# CITY OF ALBUQUERQUE

December 3, 2014

**Re: Garcia Residence – Lot 11 Black Farms  
Grading and Drainage Plan with Engineer's Stamp Dated 11-17-14  
(C13D027B)**

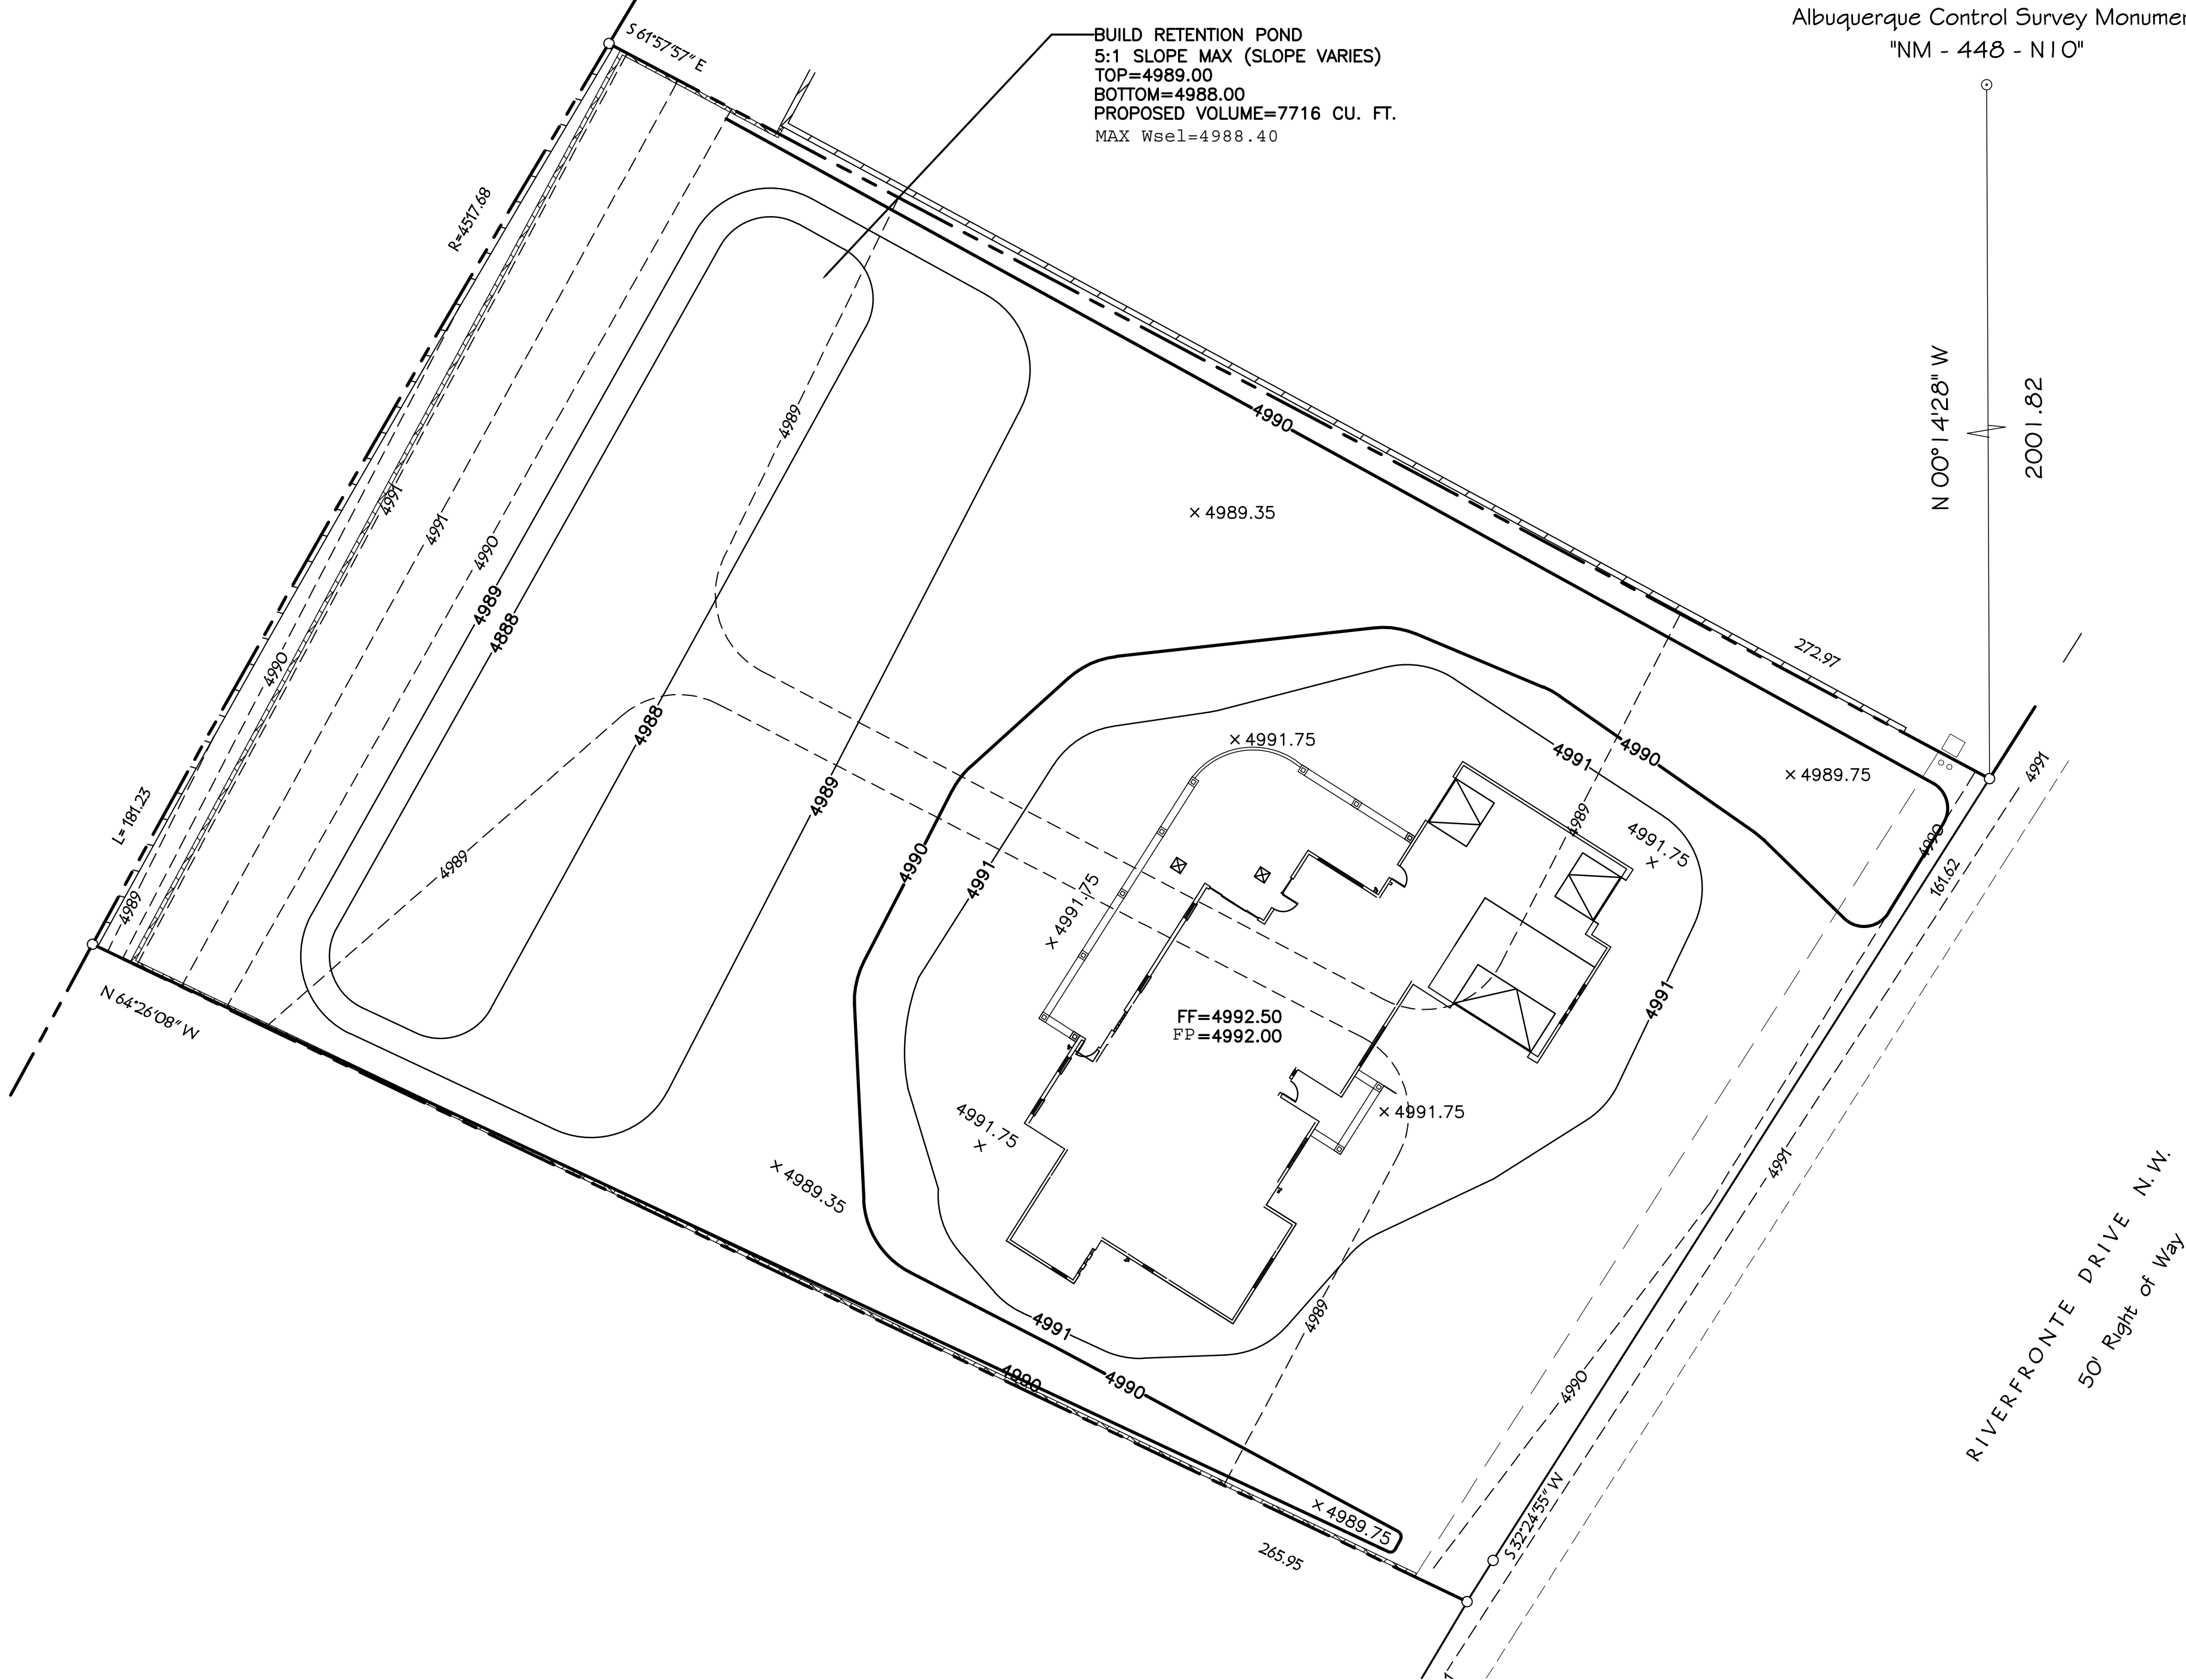
For future submittals, refer to water harvesting as First Flush. Calculate the First Flush as follows. Per the City Drainage ordinance, the 90<sup>th</sup> Percentile Storm Event, which is 44 inches, is to be managed. Reduce 0.44 inch by the 0.1 inch for the initial impervious abstraction in Table A-6 of Section 22 of the DPM. Multiply the remaining 0.34 inch by your impervious area. This is the amount of the First Flush necessary for the site.
